Subject: RE: BR/256/19/PL

Proposed Roof Plan

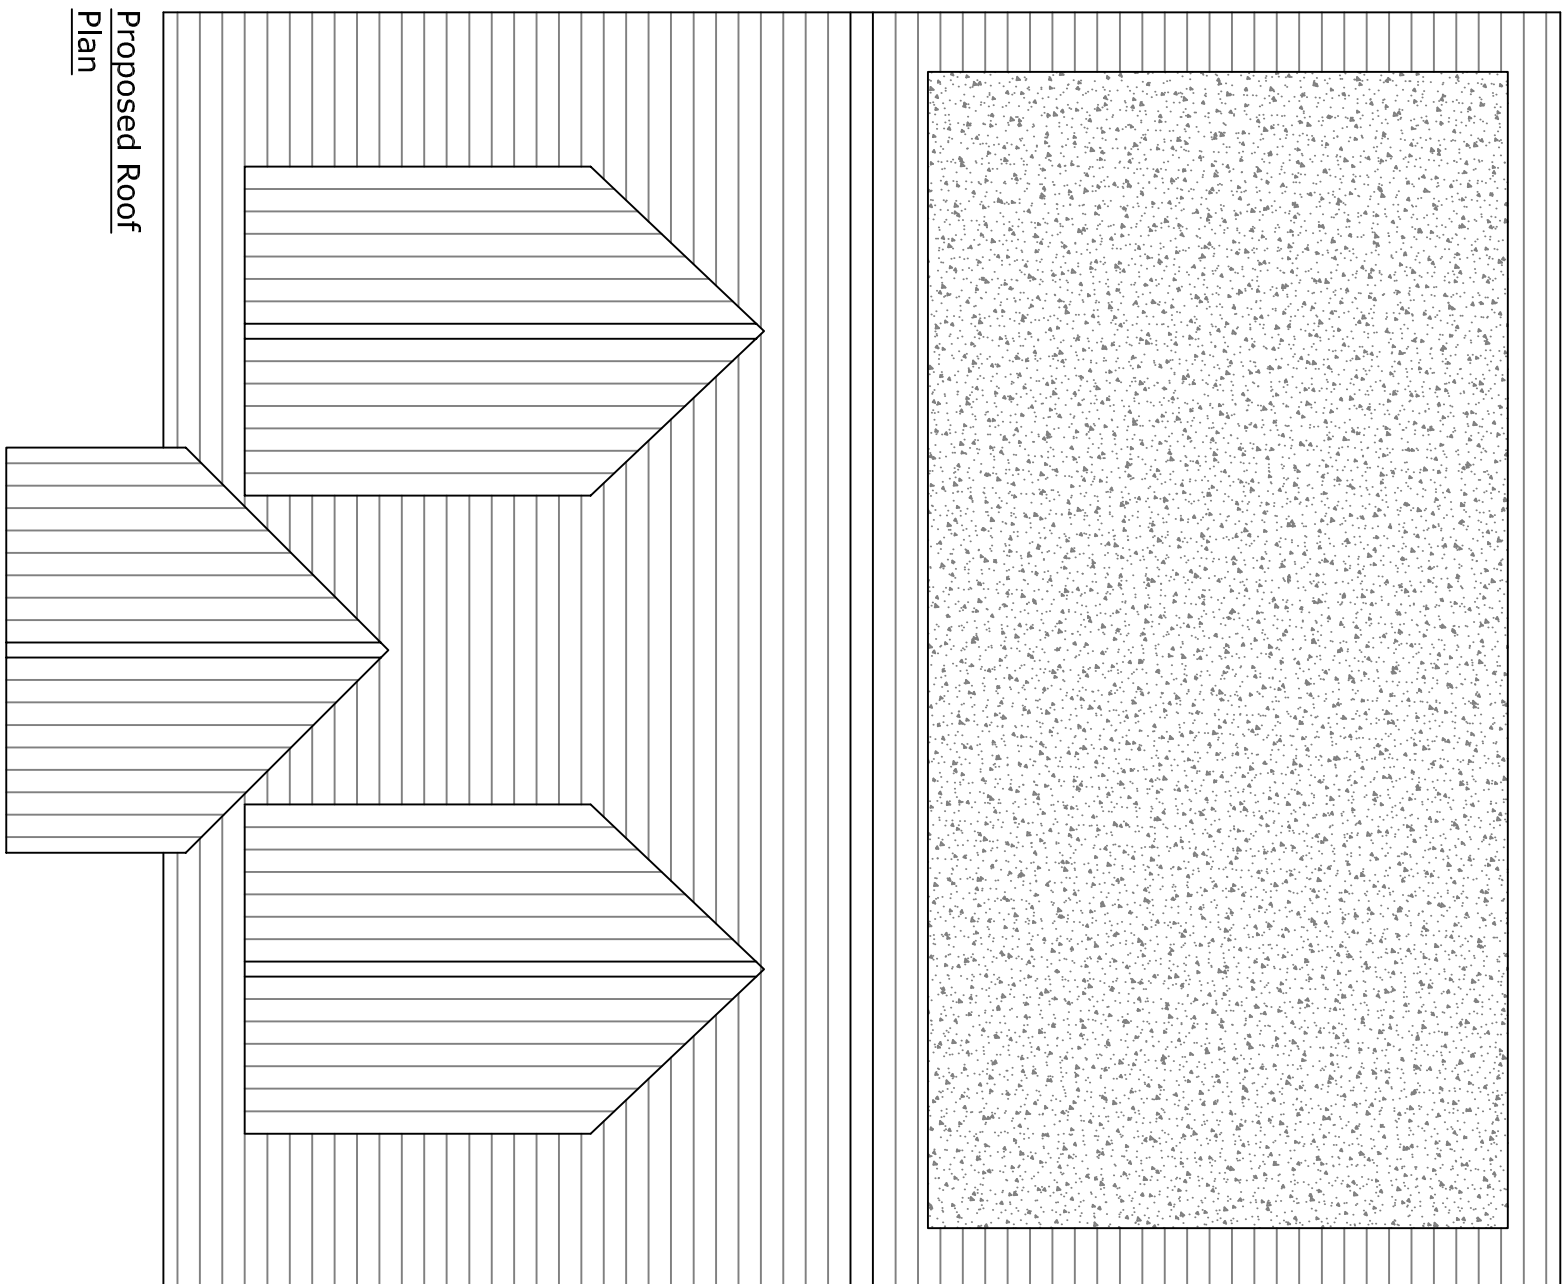
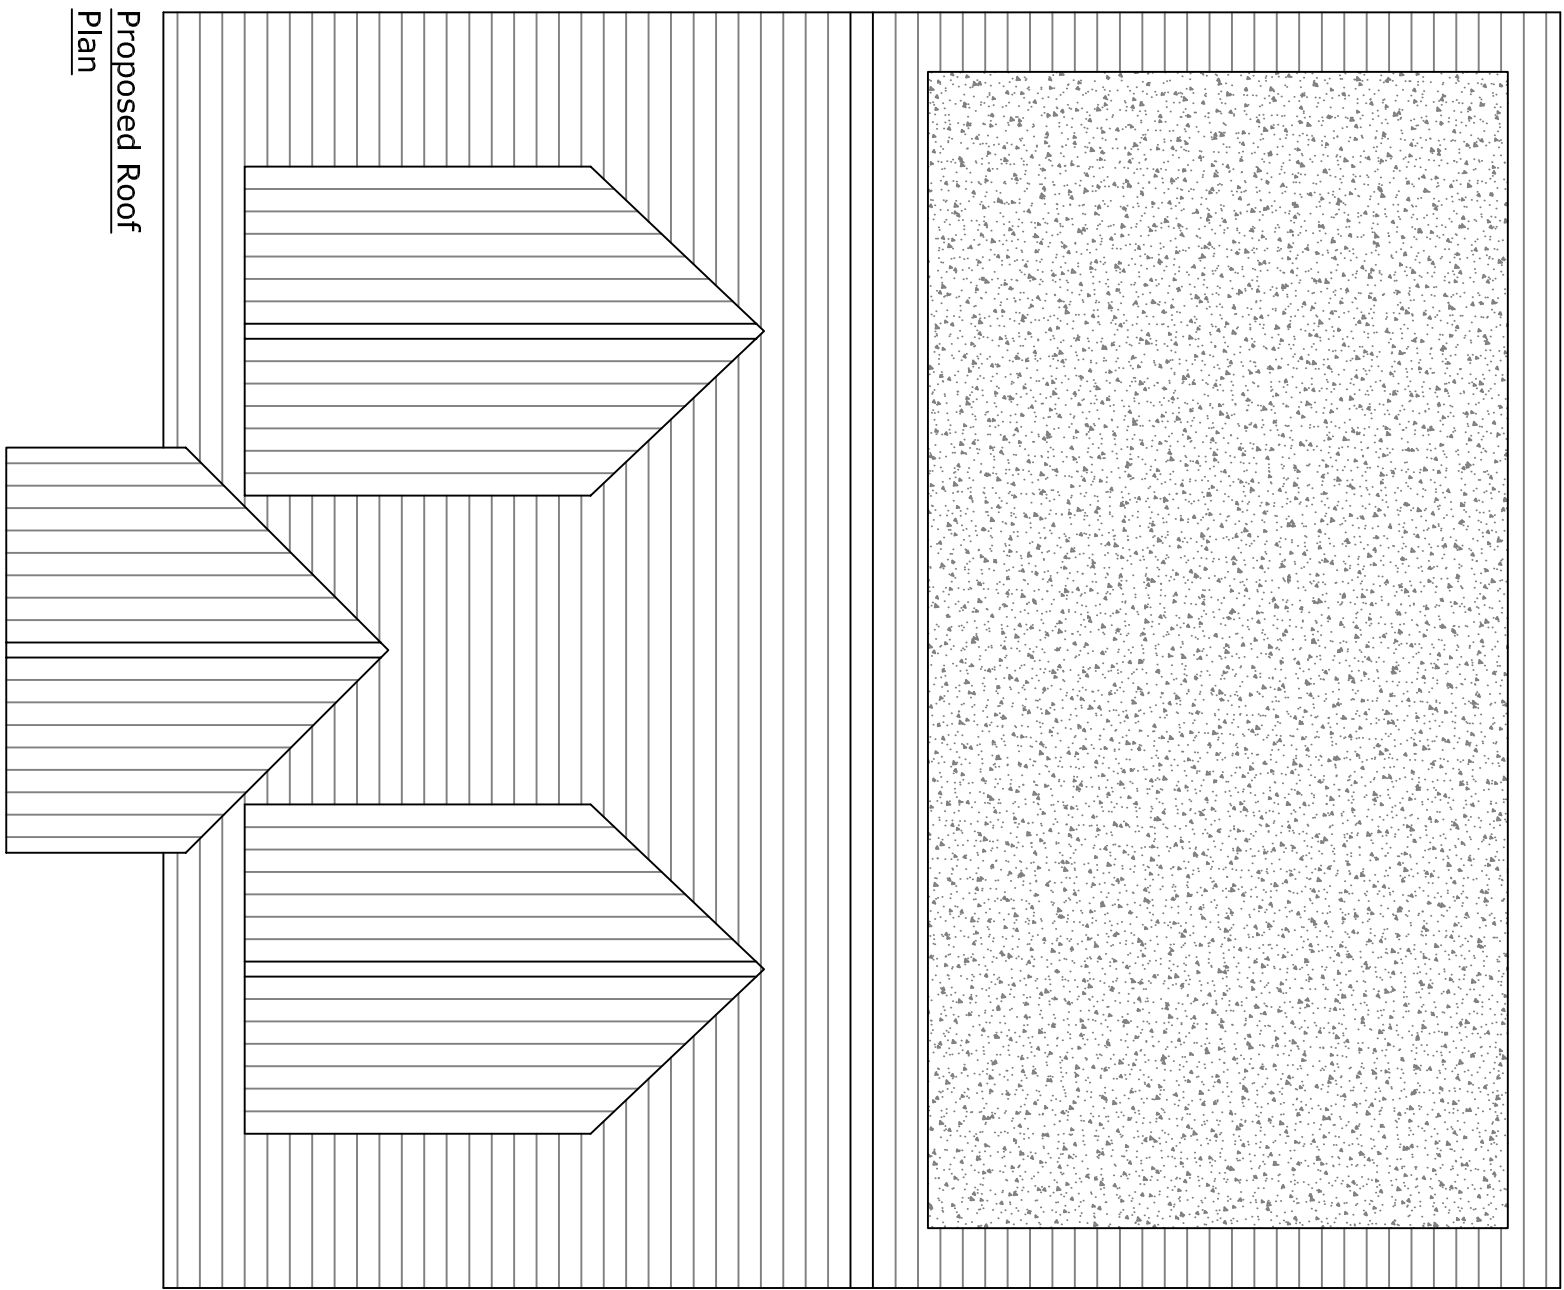
I noted from our previous email correspondence your desire to work with the Local Authority to achieve a development on this site. Having discussed possibilities with management, we would be happy for you to remove the rear dormer window and utilise velux style rooflights, positioned 1.7m above FFL. This would result in a reduction in bedrooms from 3 down to 2. This would provide a development of kinds on the site, which would overcome the concerns raised.

Proposed First Floor Plan

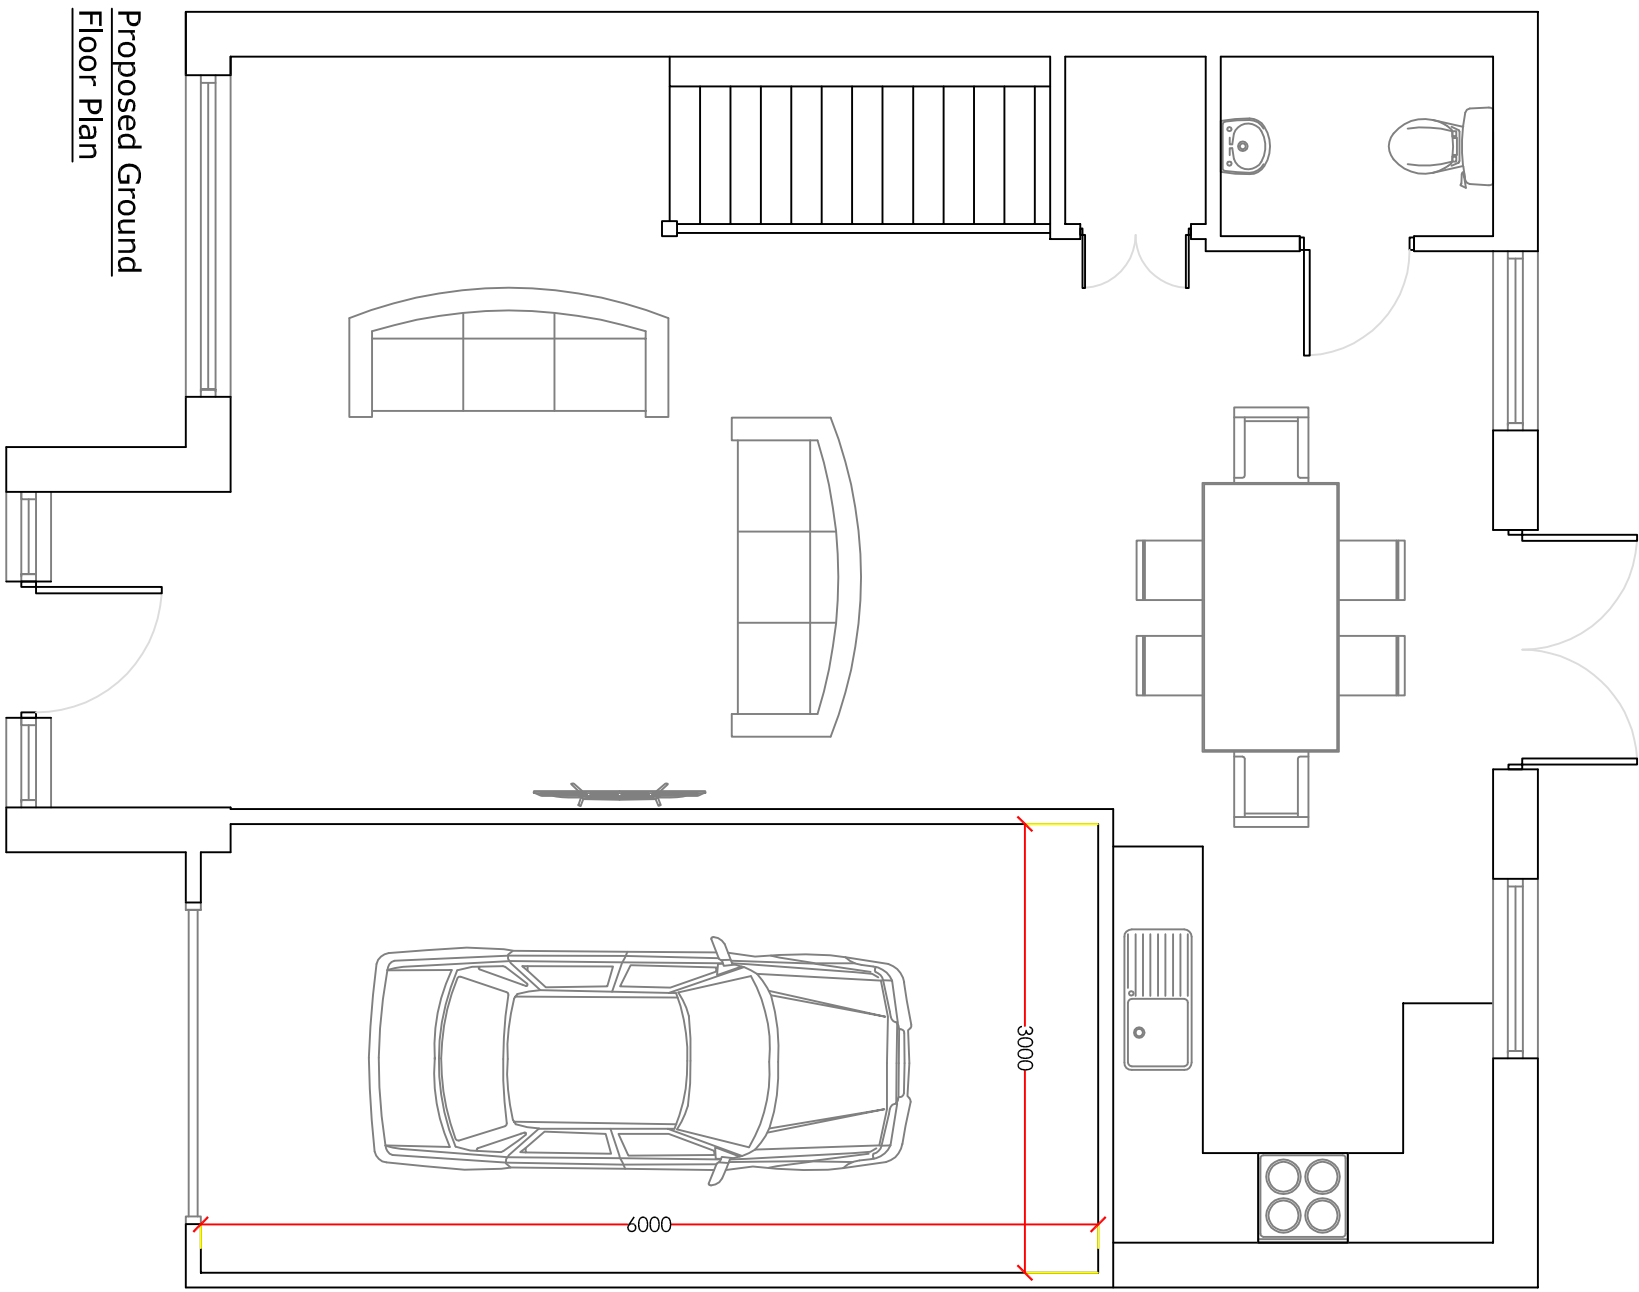
- 2) Could you please provide a line on the plans showing where the pitch of the roof cuts into the headspace? This will allow me to have a better understanding of how much internal space is usable.

- 3) Please label the third room accordingly – if this is intended on being a bedroom, please show it as such. If it is to be a study or a snug etc... then please label/furnish accordingly. This is to provide all parties with sufficient clarity in moving forward. I envisage if this were to be a bedroom then it would not likely meet with internal space standards.
